From: Martyn White
Sent: 22 February 2019 10:14
To: Planning.Responses
Cc: Zac Denton
Subject: A/2/19/HH & A/3/19/L

A/2/19/HH & A/3/19/L

Weavers is itself a two storey flint faced cottage with red brick dressings and quoins. The windows are timber casement. The property has been extended to the rear of the property to provide for a single storey snug and kitchen.

FIRST FLOOR

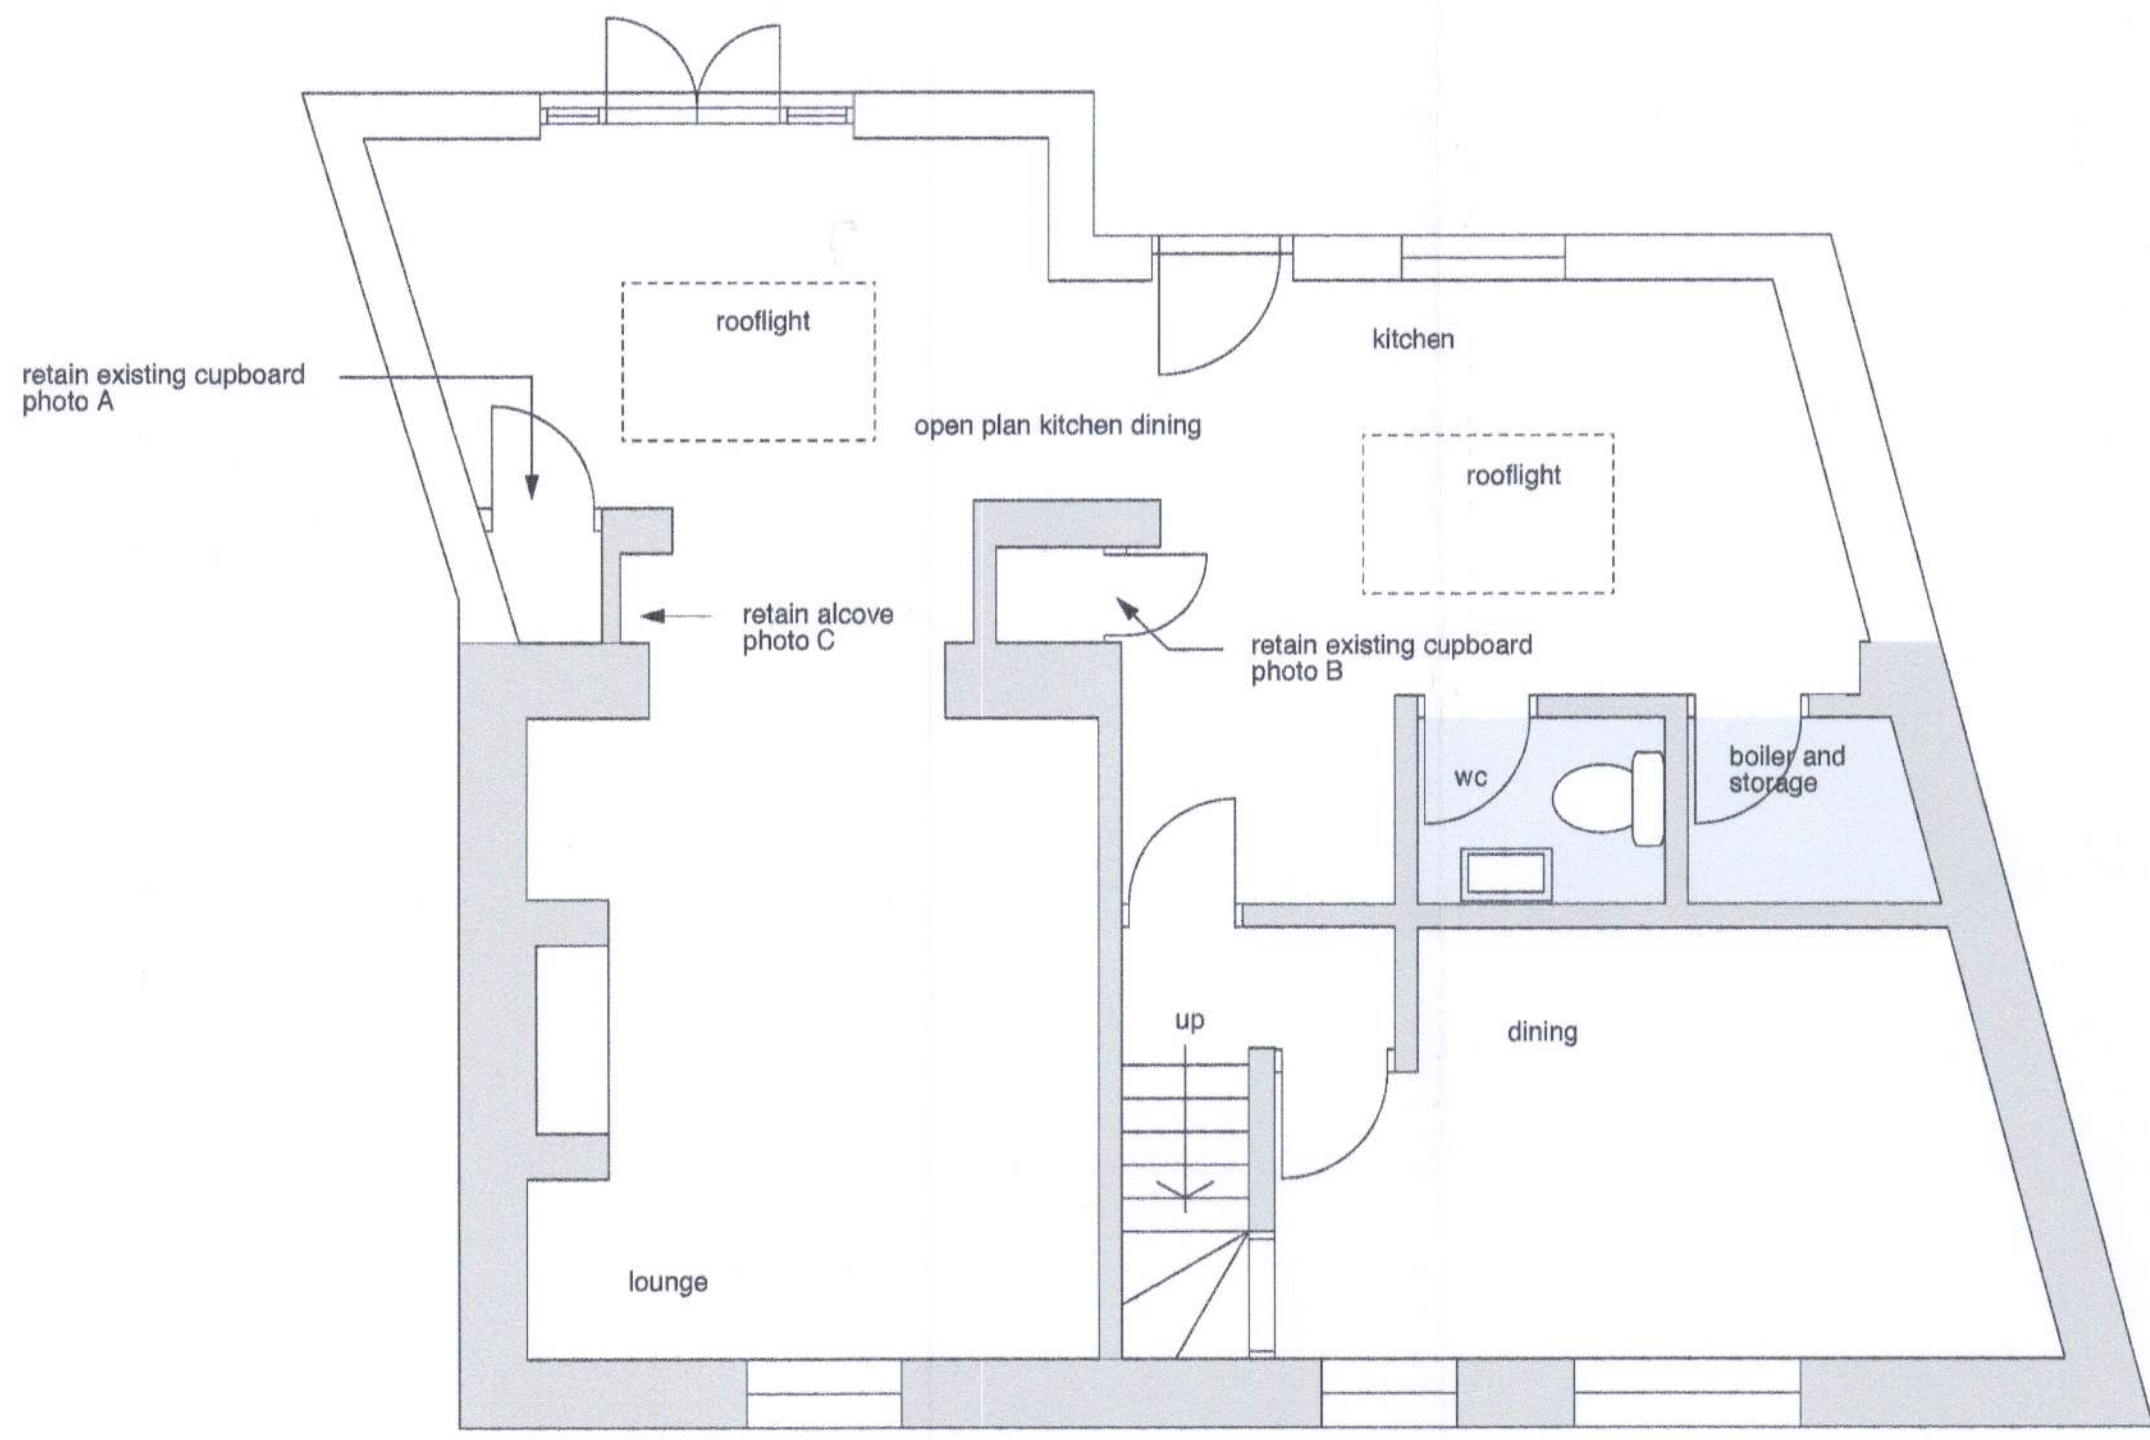
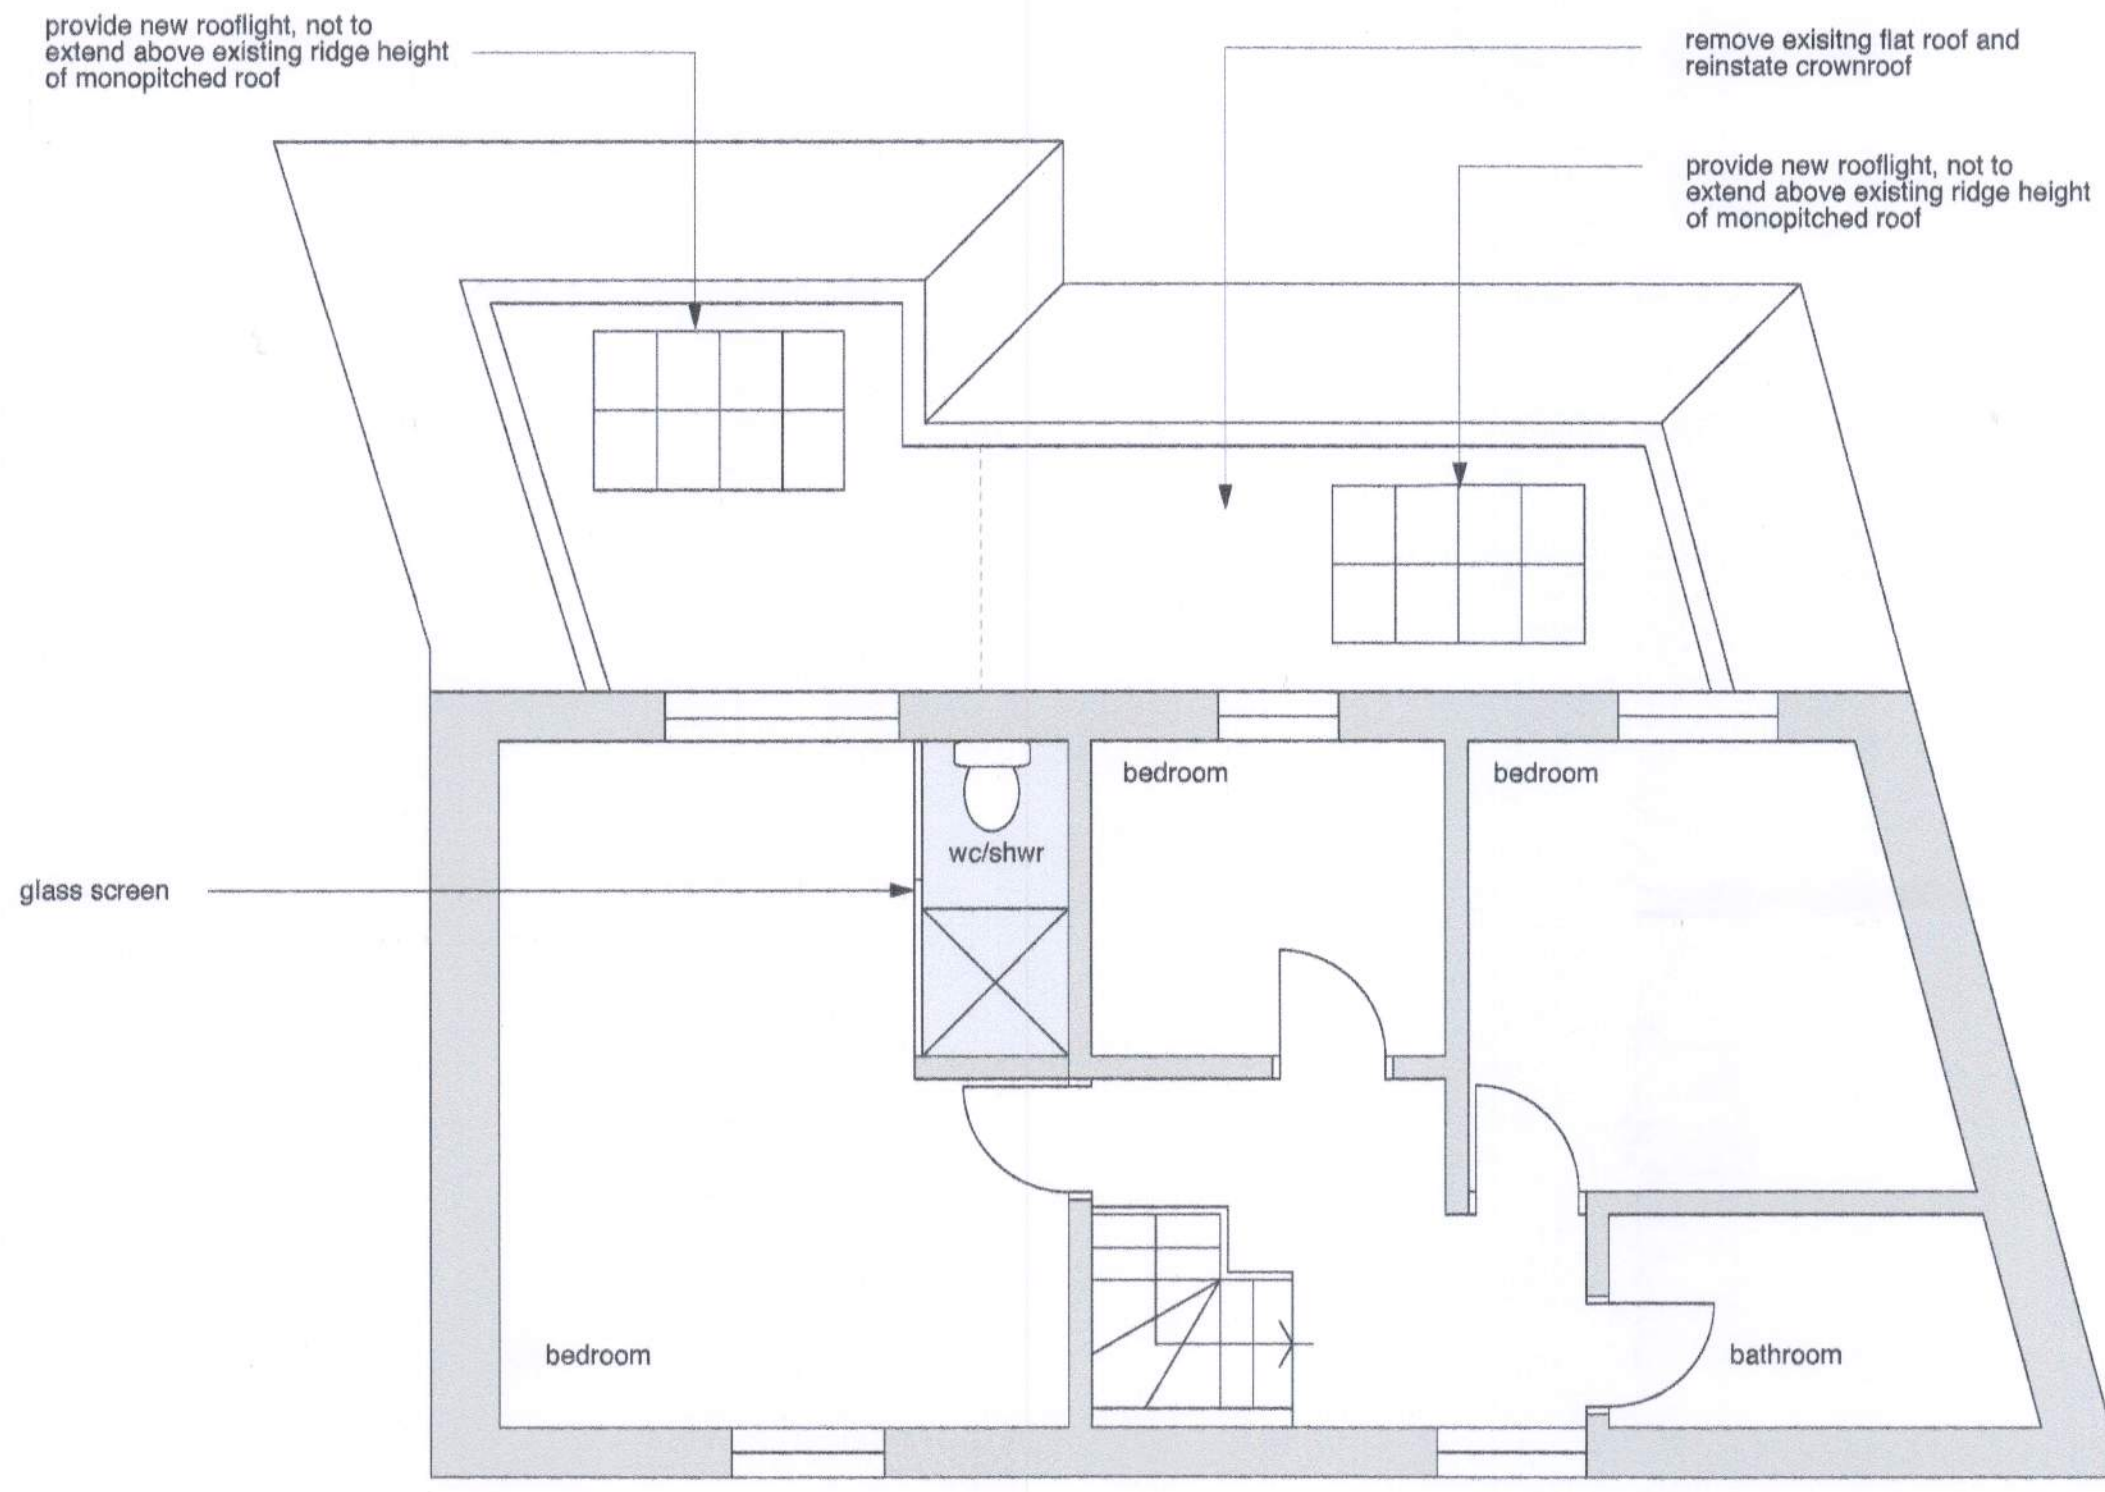
The internal works to make shower on first floor are of a scale that the character of the room will not be affected. There is some concern regarding the glass screen; how will it look etc., and therefore what impact will it have upon the room? Can further information be provided regarding this element of the proposal?

PROPOSED

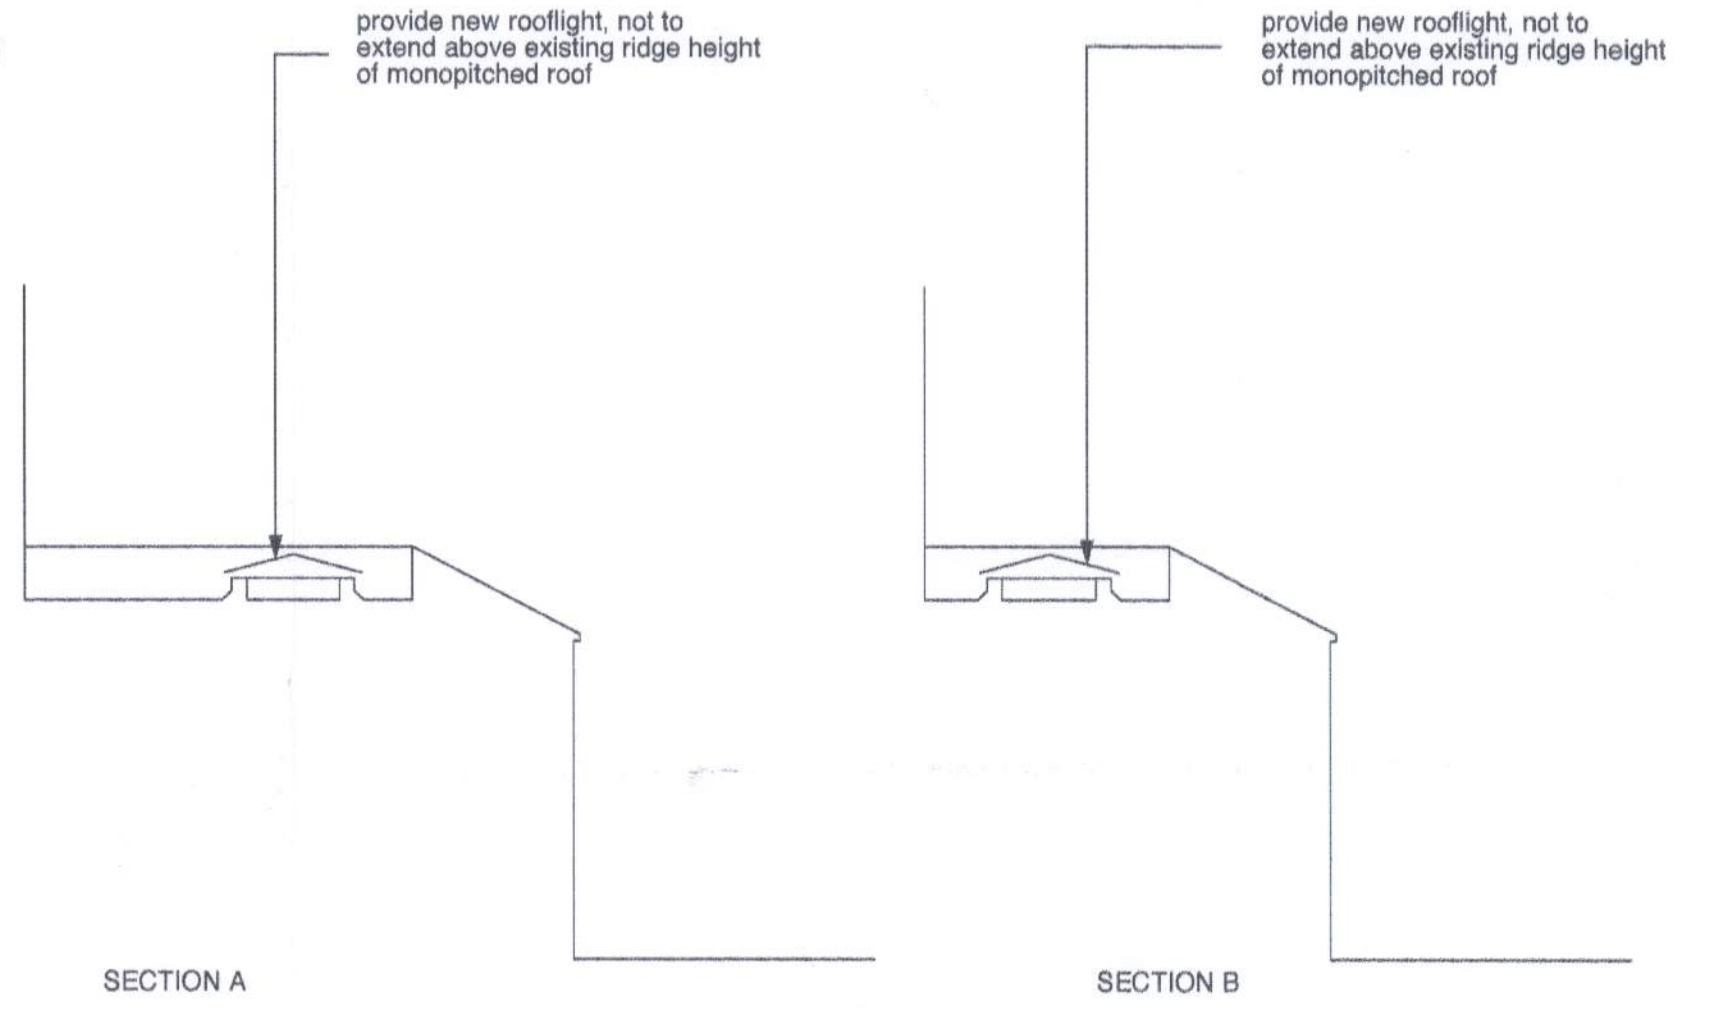
Likewise, the new rooflights will be located within the later extension and of a design so that they would be hidden behind the ridge of the existing mono-pitched roof. Further, the rooflights would only directly affect more modern fabric, and any loss would not cause harm to the listed building. This element of the proposal is therefore also considered to be acceptable.
